# Response to Submissions

*Alspec Distribution Warehouse*

This Submissions Report has been prepared on behalf of HB+B Property to address the matters raised by government agencies, Penrith City Council and the community during public exhibition of the proposed development at 221-235 Luddenham Road, Orchard Hills.

The State Significant Development Application (**SSDA**) was lodged with DPHI in July 2025 (SSD-81434988). The SSDA was placed on public exhibition for 28 days between 21 August 2025 and 17 September 2025.

Figure 4-2 Indicative AIBP construction timeline

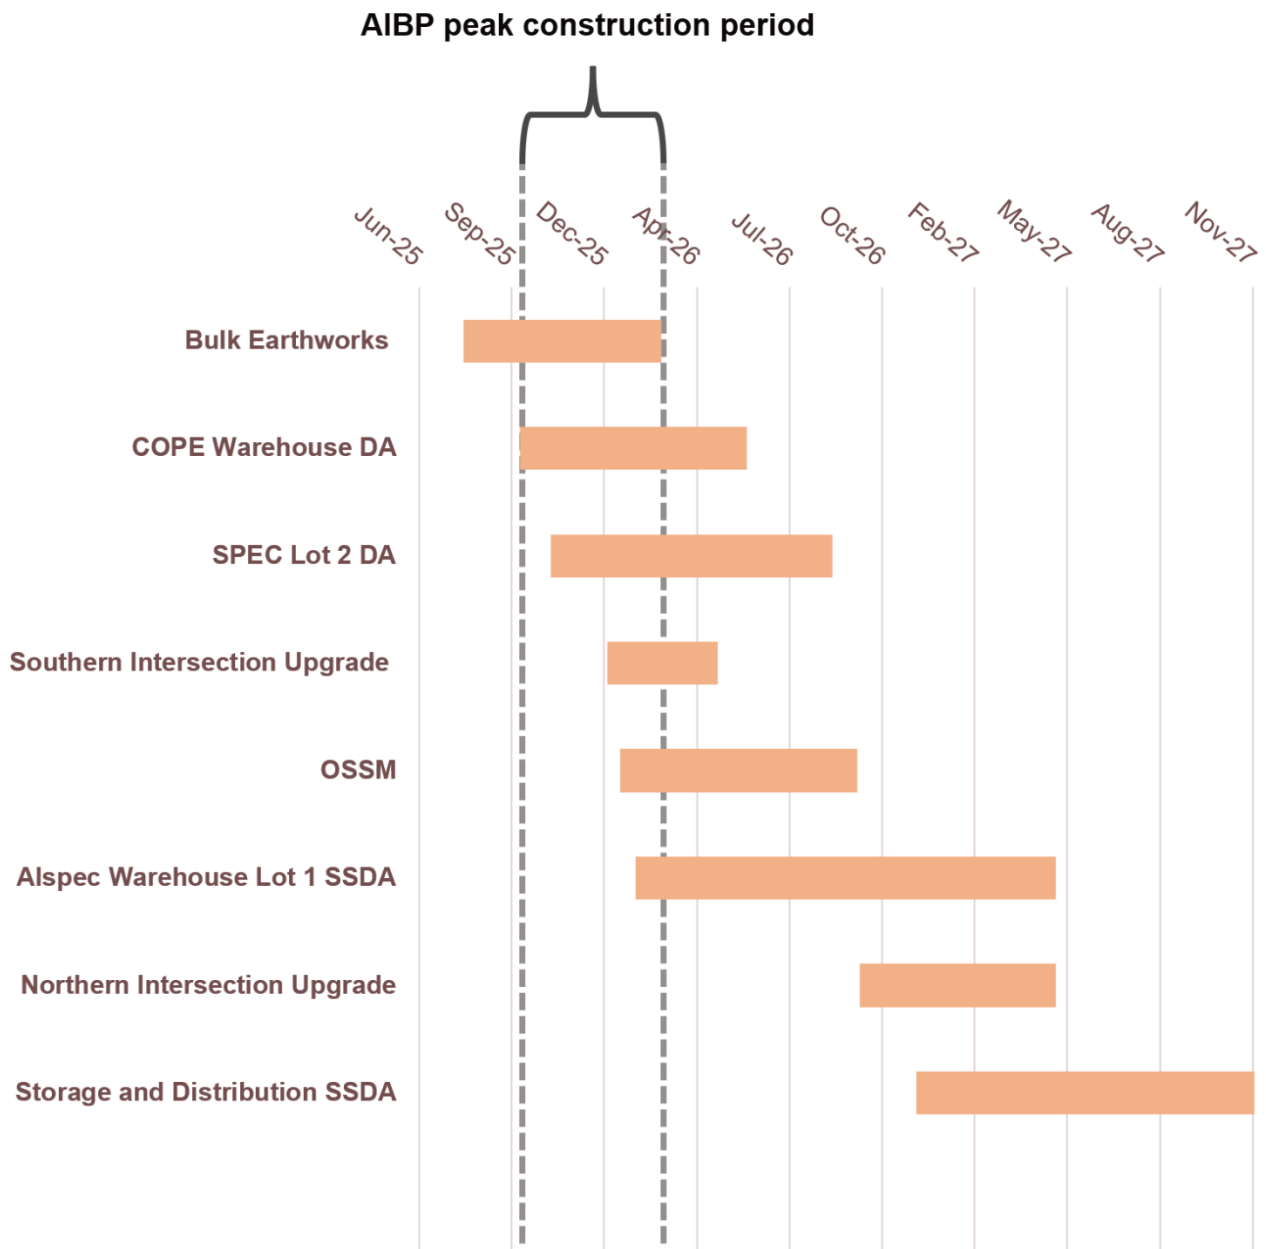
Summary of Issue Raised	Response	Supporting Document
<b>NSW Department Of Planning, Housing and Infrastructure</b>		
<p>1. The Submissions Report must identify and detail the relationship and timing of this development in relation to other related infrastructure and development applications. A staging plan for the Alspec Industrial Business Park must be submitted, clearly outlining the indicative timing for site establishment, intersection upgrades, and infrastructure provision, as well as other developments to be undertaken via separate development applications.</p>	<p>A staging plan has been submitted with the Estate Master Plan. This shows the timing of each of the Development Applications submitted to date, as well as key infrastructure such as the Patons Lane / Luddenham Road upgrade and the Southern Intersection upgrade.</p>	<p>Appendix A</p>
<p>2. The staging plan must also show the duration of construction for other developments. Any technical assessments (such as traffic studies) must be updated to reflect any changes in timing, ensuring that traffic assessments account for interim arrangements if intersection works are not completed at the start of operations.</p>	<p>The construction timefarme reflects the timing of all key Infrastructure. This timing is reflected in the Traffic Impact Assessment. The Patons Lane / Luddenham Road upgrade will be in operation prior to the occupation of this warehouse.</p>	<p>Appendix A (Construction Pogram) and Appendix B (Traffic Impact Assessment)</p>

Figure 5-1 Peak operational daily traffic profile - Storage and Distribution warehouse

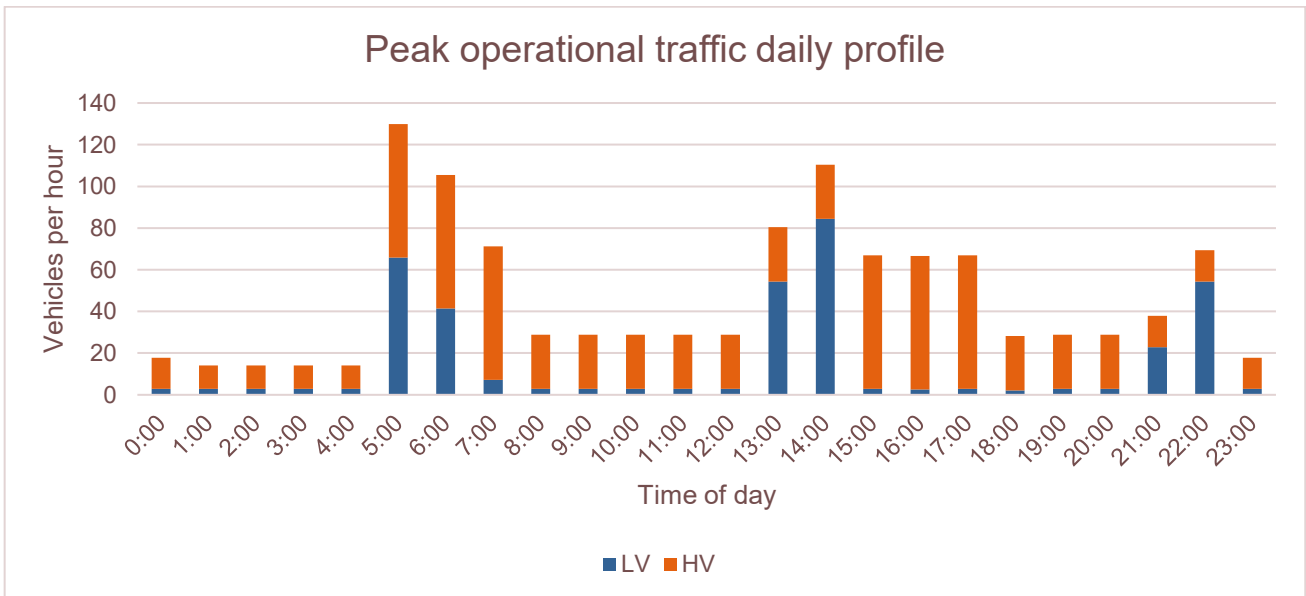
Summary of Issue Raised	Response	Supporting Document
<p><u>Noise Impact Assessment</u></p> <p>6. Please confirm that the hourly distribution and composition of heavy vehicle movements used in the Noise Impact Assessment (NIA) (Table 5.6) is consistent with the peak operational traffic profile in the TIA (Figure 5-1). In particular, clarify whether the night-time period (1:00 am–5:00 am) accounts for B-double movements that may be concurrently loaded or unloaded. If there are discrepancies, provide justification or update the noise model to reflect the worst-case scenario.</p>	<p>The assumptions for hourly distribution of heavy vehicles, based on information supplied by the client are consistent between the NIA and TIA. Section 2.6 of the NIA provides assumptions for heavy vehicle movements. There is no overlap of B-Double and semi-trailer movements between 9pm and 5am. Between 1am – 5am only semi-trailers are anticipated and these movements (14) have been assessed as a worst case night impact for the NIA as per Table 2.2 and 5.6.</p>	<p>Appendix C (Noise Impact Assessment) Section 2.6</p>
